ATTACHMENT 1

In order to finalise the Department's assessment, additional information is required including but not limited to the following:

EIS Appendix 1: Site Plans, Swept Path Diagrams and Equipment Technical Drawings

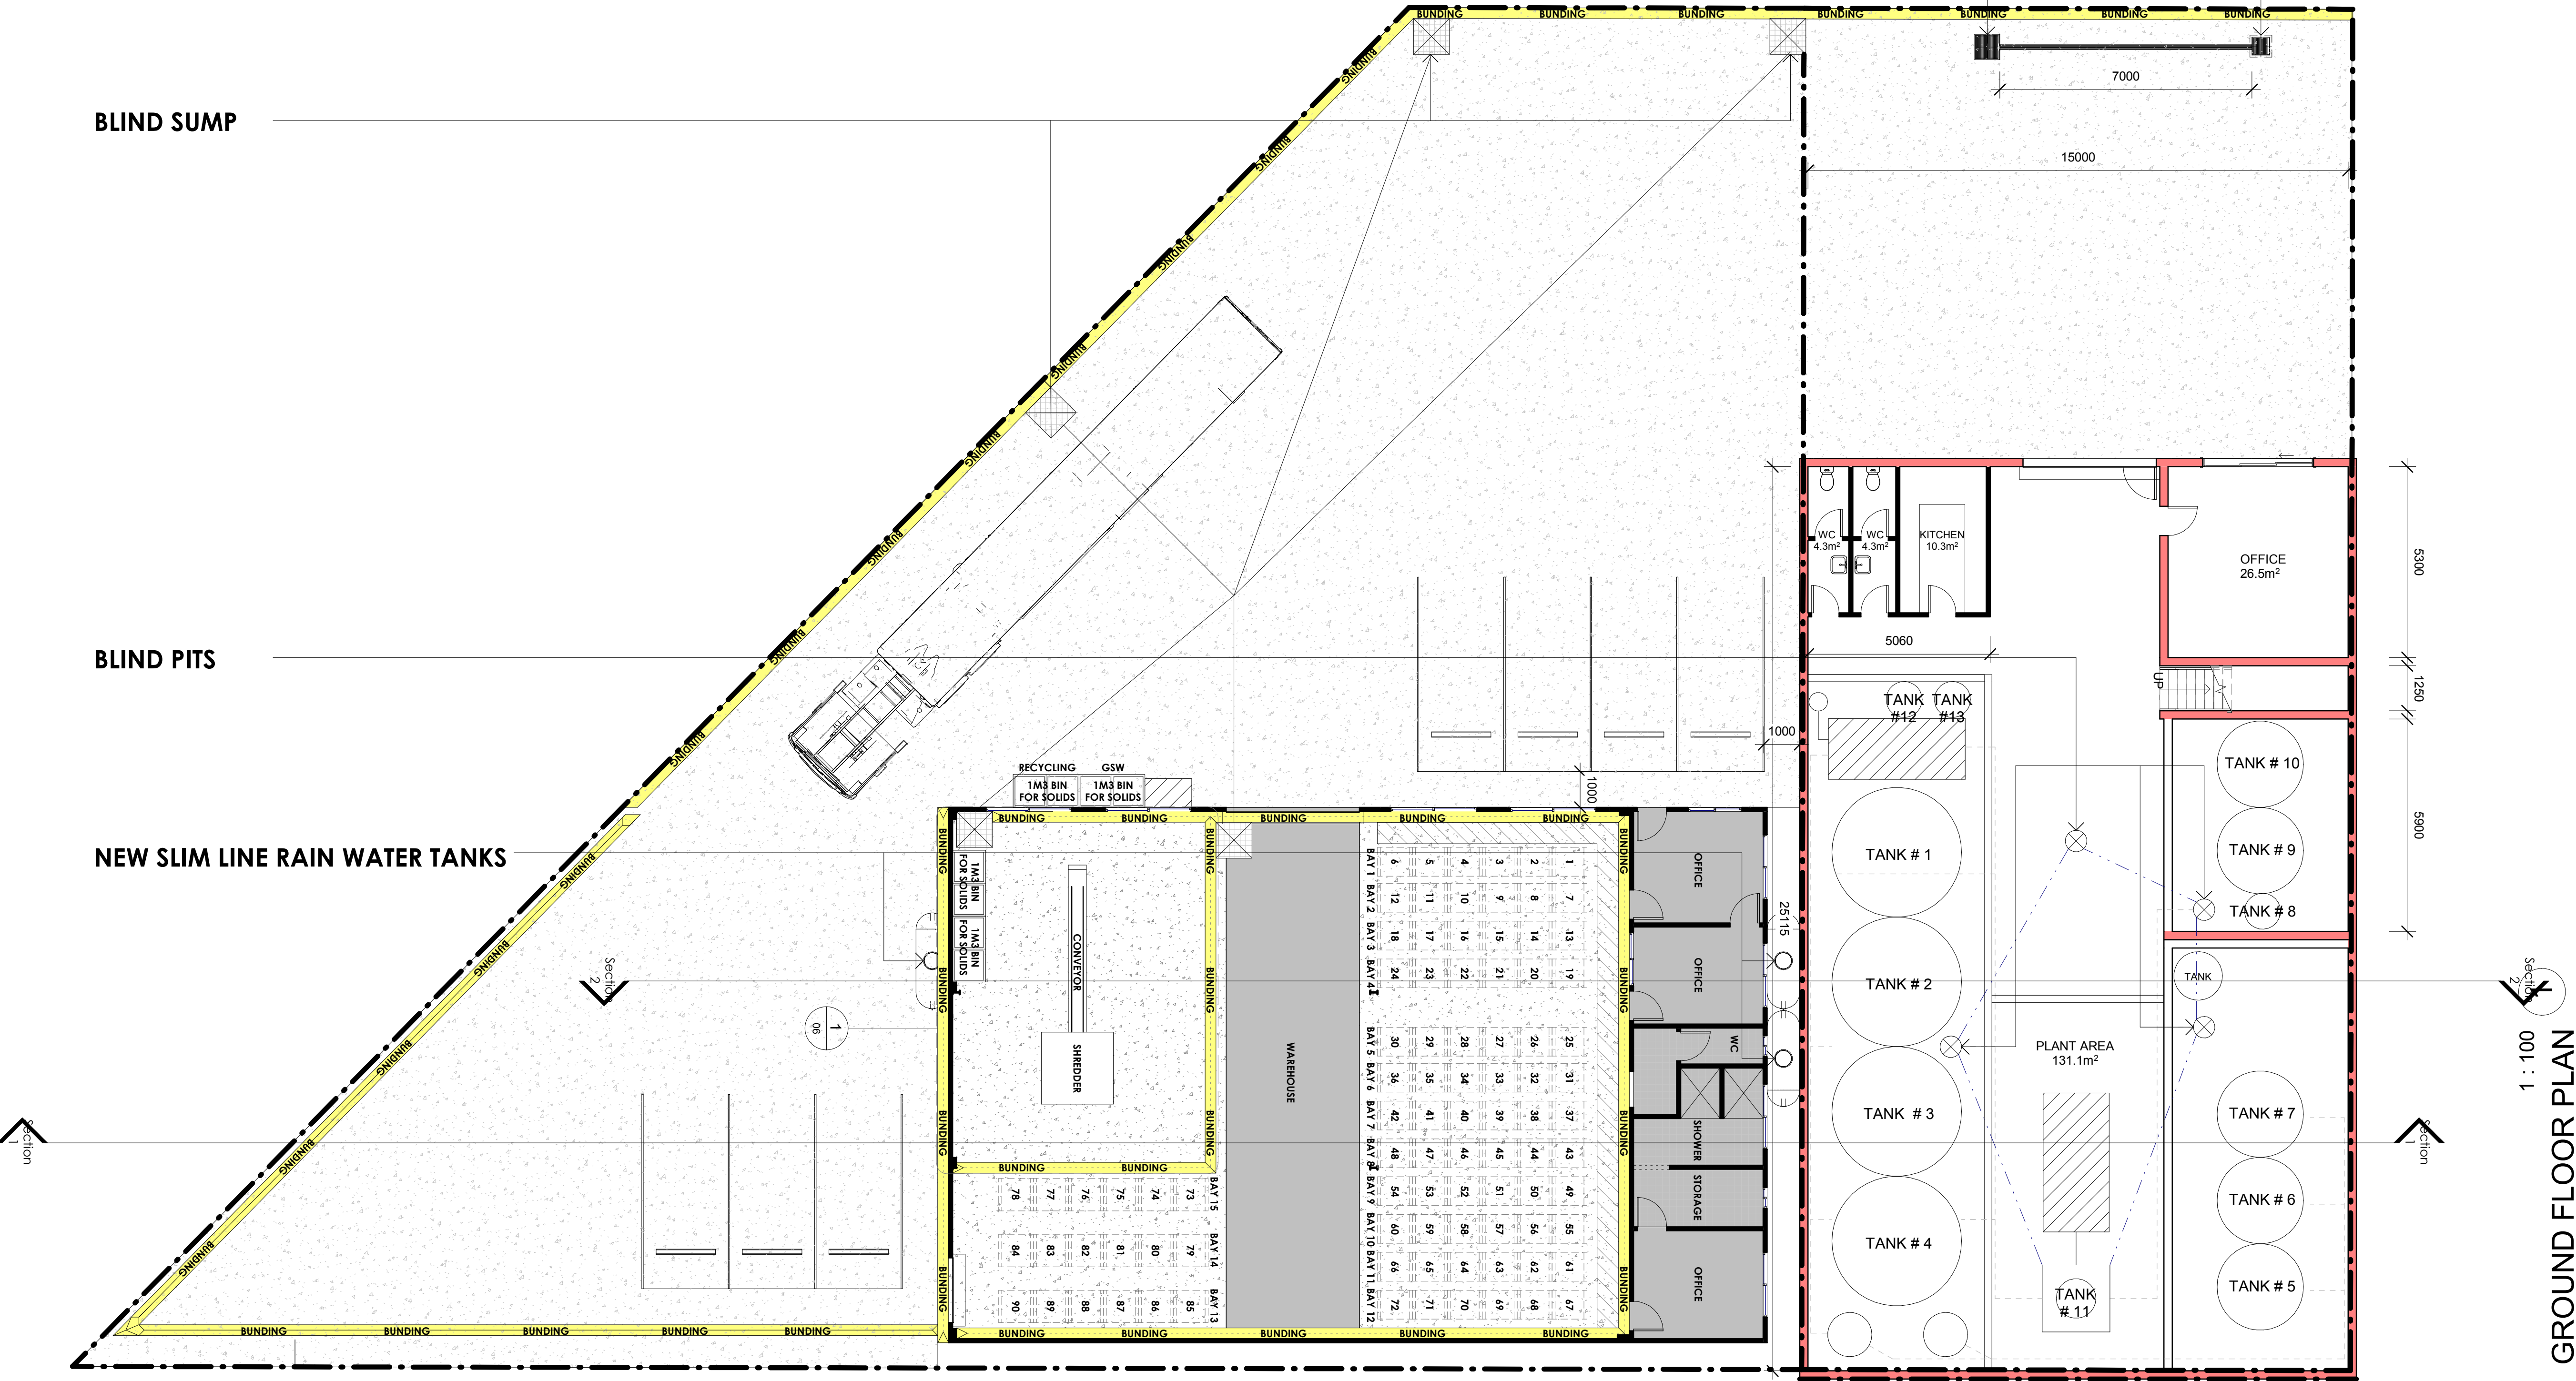
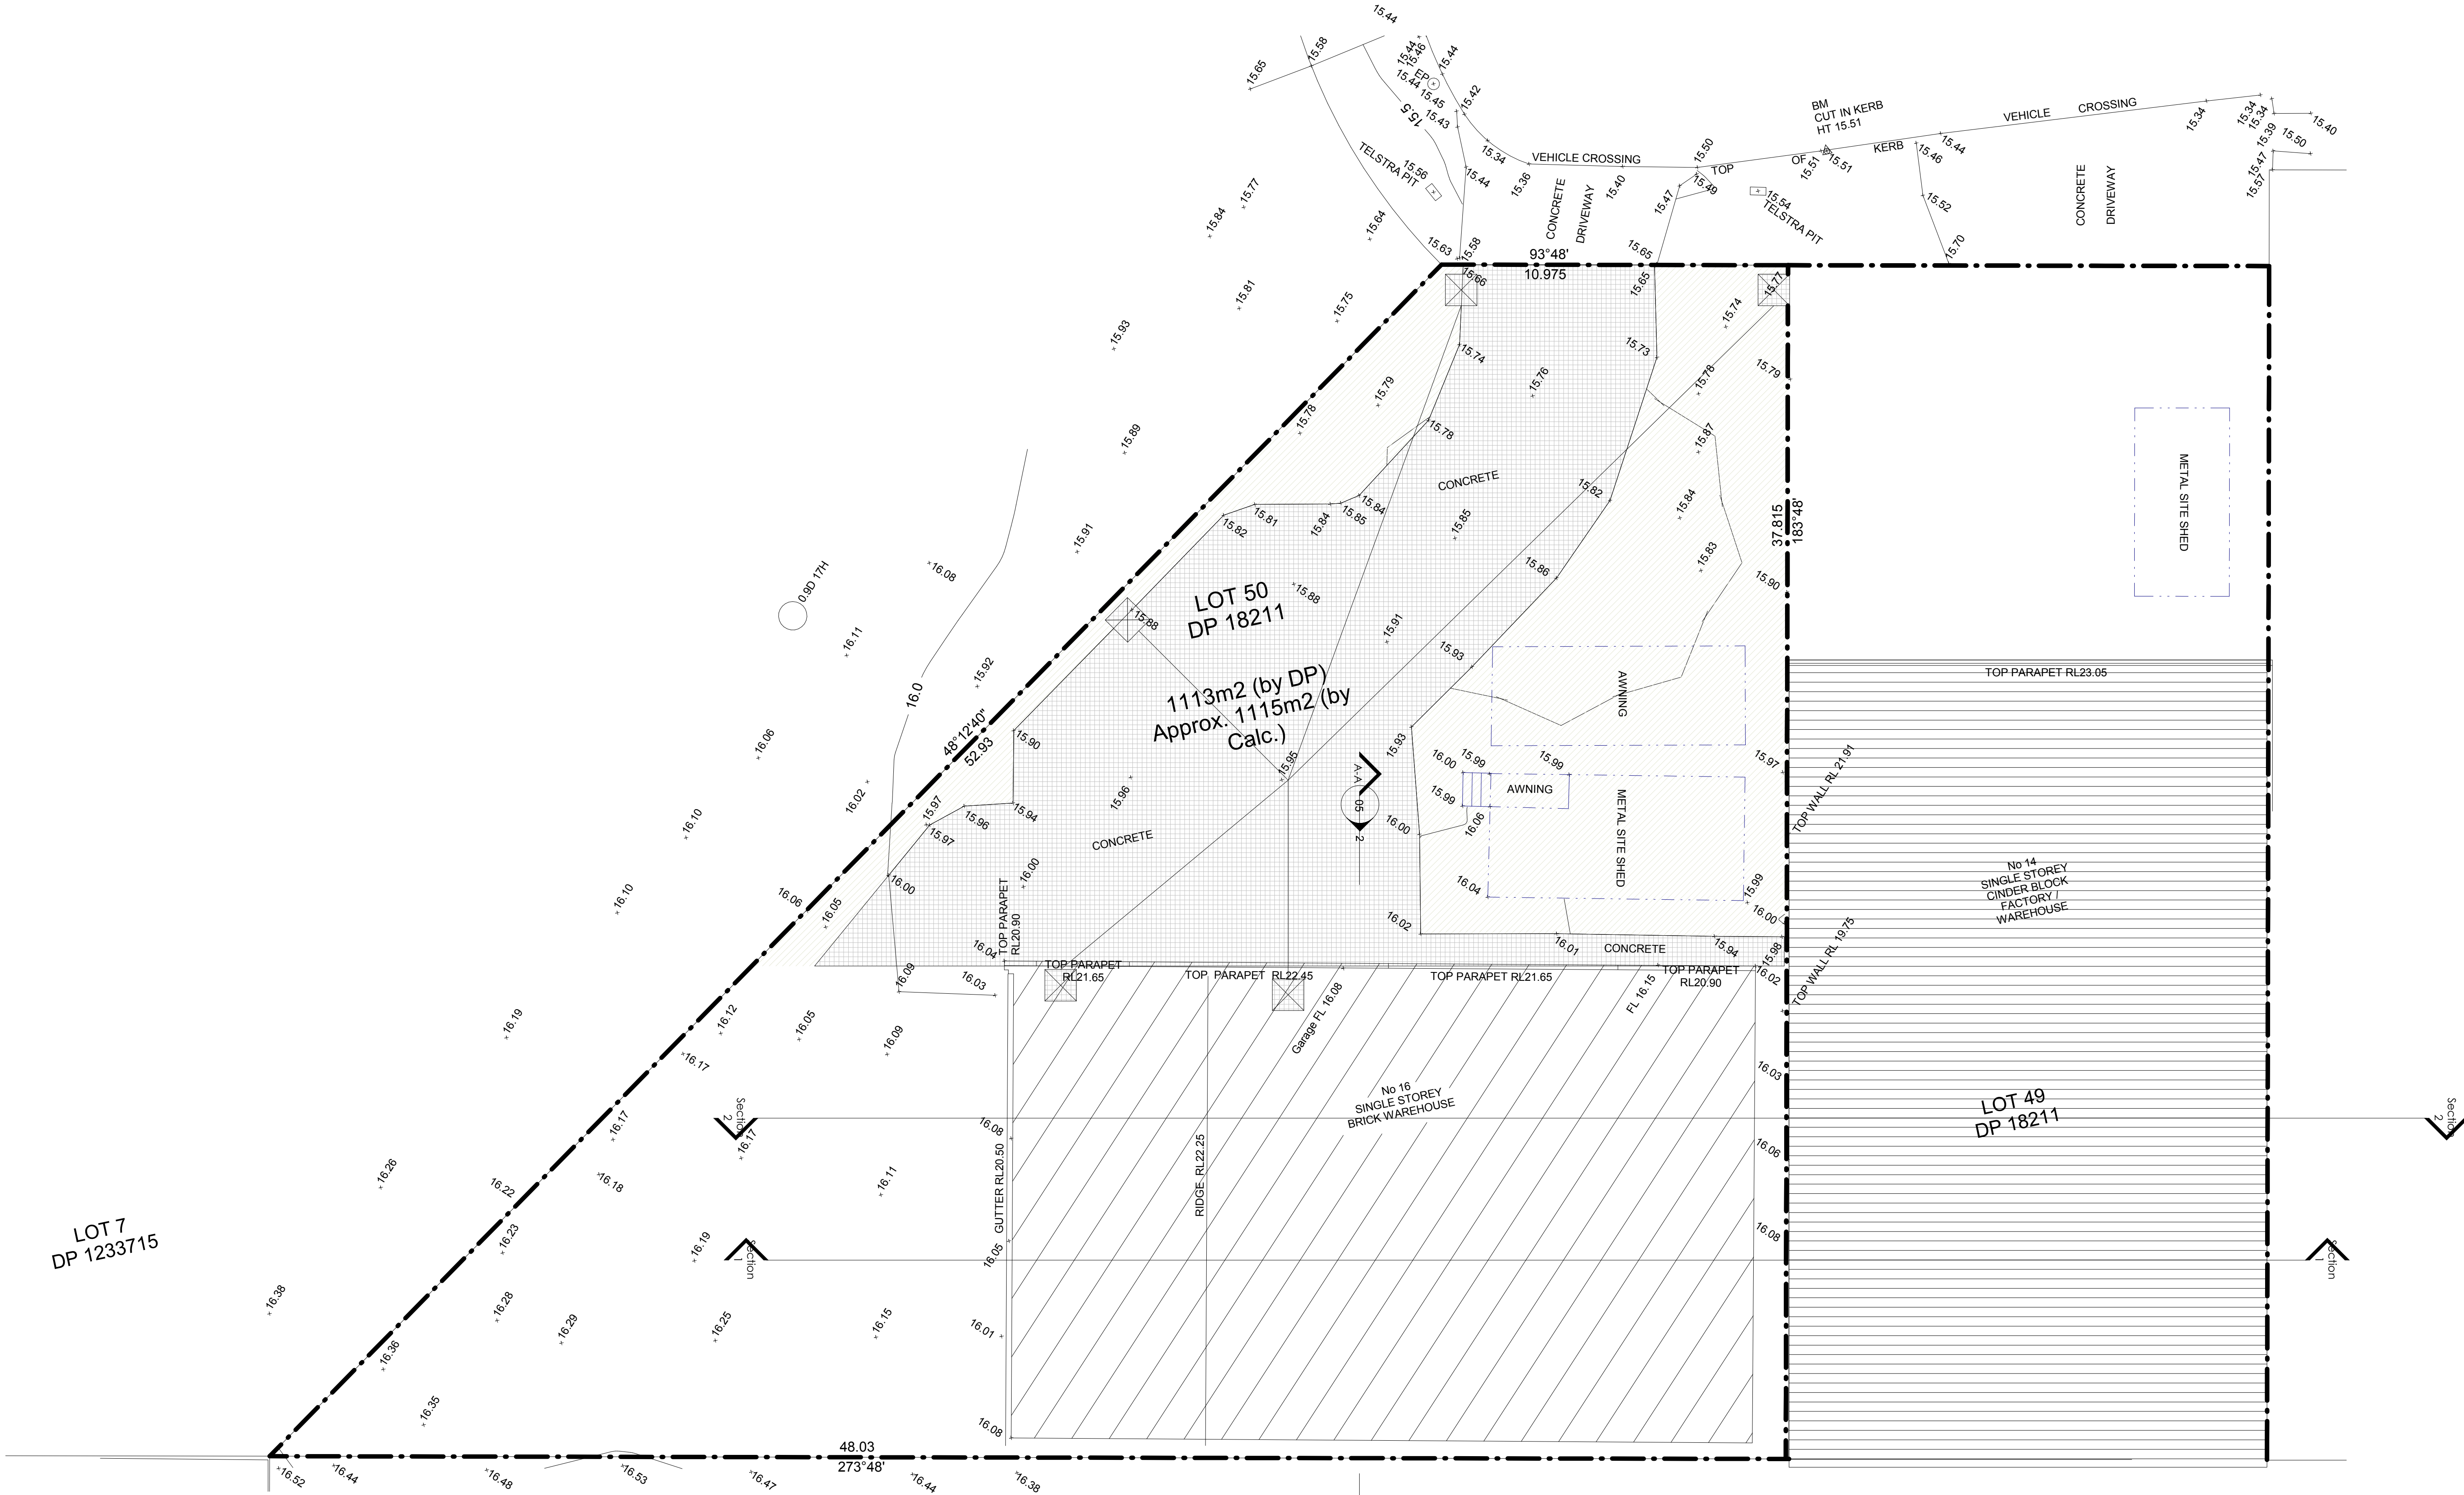
- The EIS states that 'no tree removal' would occur as part of the proposal. However, the plans for 16 Kiora Crescent show the removal of the existing demountable site office and laying of hardstand across the site across, an area currently grassed and containing at least one tree. Please clarify whether any vegetation removal is proposed as part of the EIS.

- The site plan provided in Appendix 1 indicates that works would be carried out to widen the site entrance at 16 Kiora Crescent. Please provide further description of these works. The width of the proposed driveway shown in the site plan extends over two existing stormwater pits. Please advise if these stormwater pits would be required to be relocated or managed to allow the widening of the site entrance. The proposed driveway widening works should also form part of the proposed development description and the be reflected in the QS report.

- Update site plans to show the dimension of the site access upgrades proposed for the driveway entrance at 16 Kiora Crescent.

1 SHREDDER DETAIL
1 : 50

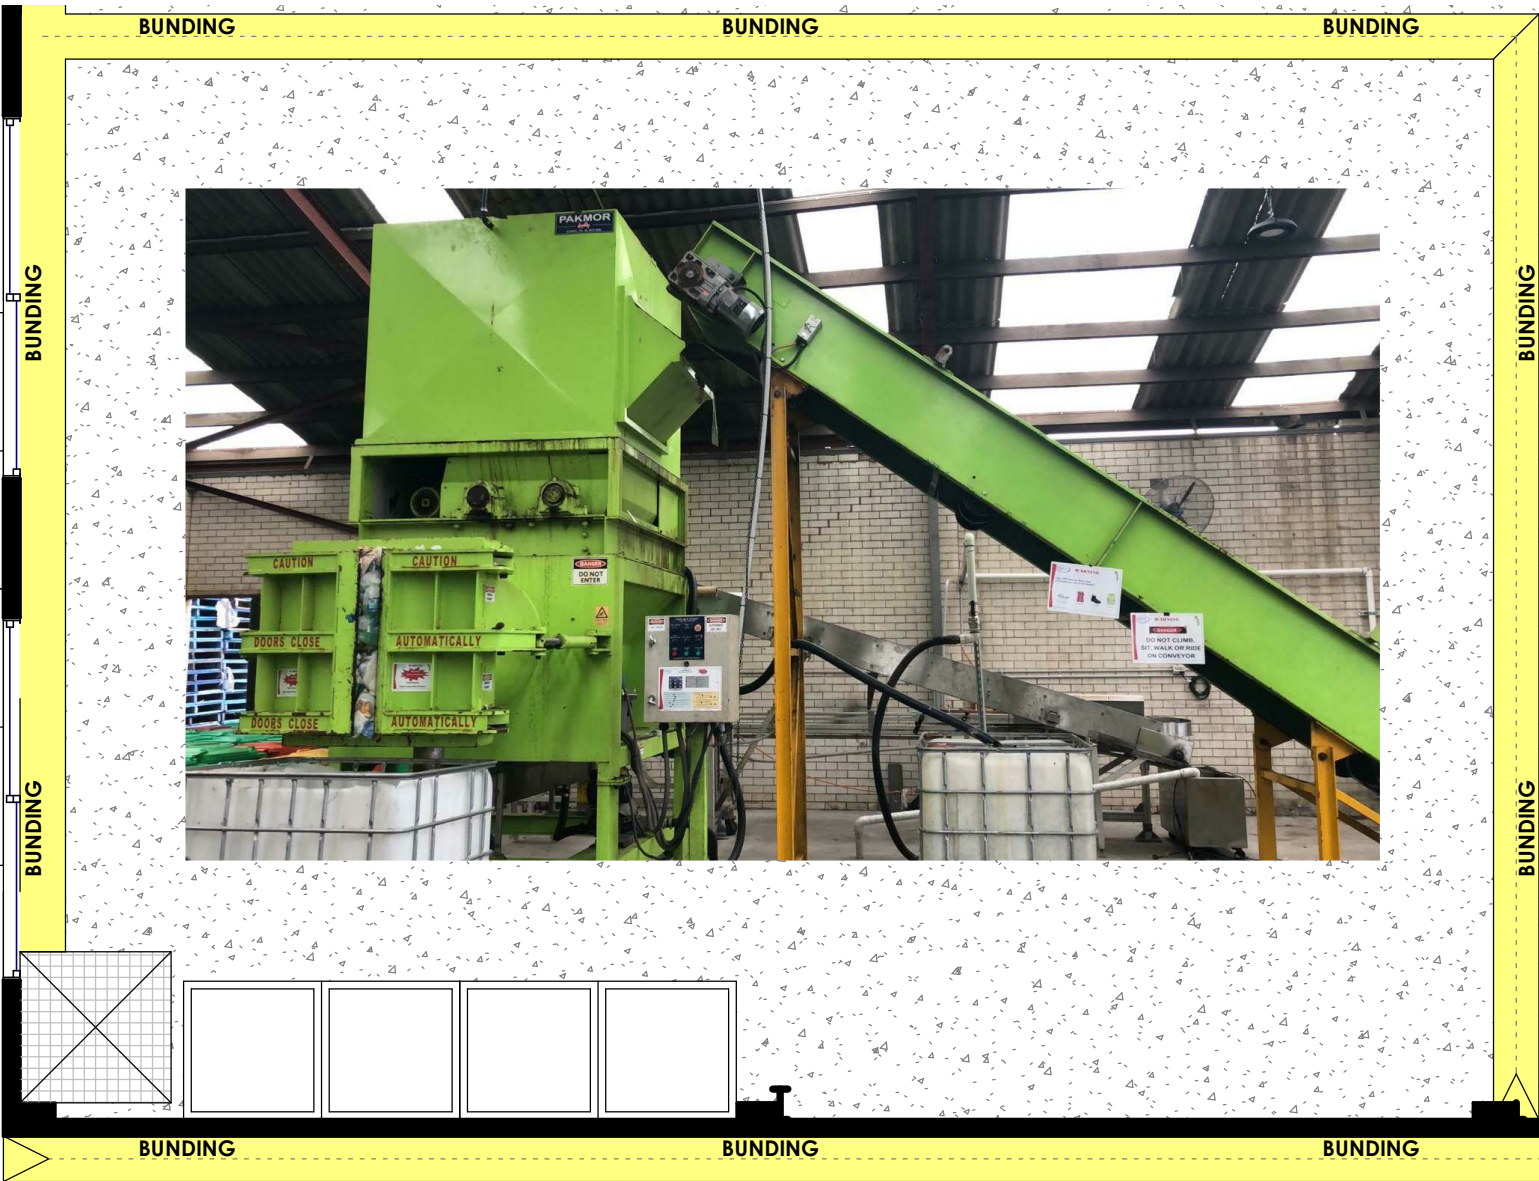
of a shredder on site and the increase in vehicle movements and intensification of operation of the site the AQIA should be updated to include an assessment of other potential pollutants (including VOCs, PM10 and PM2.5)
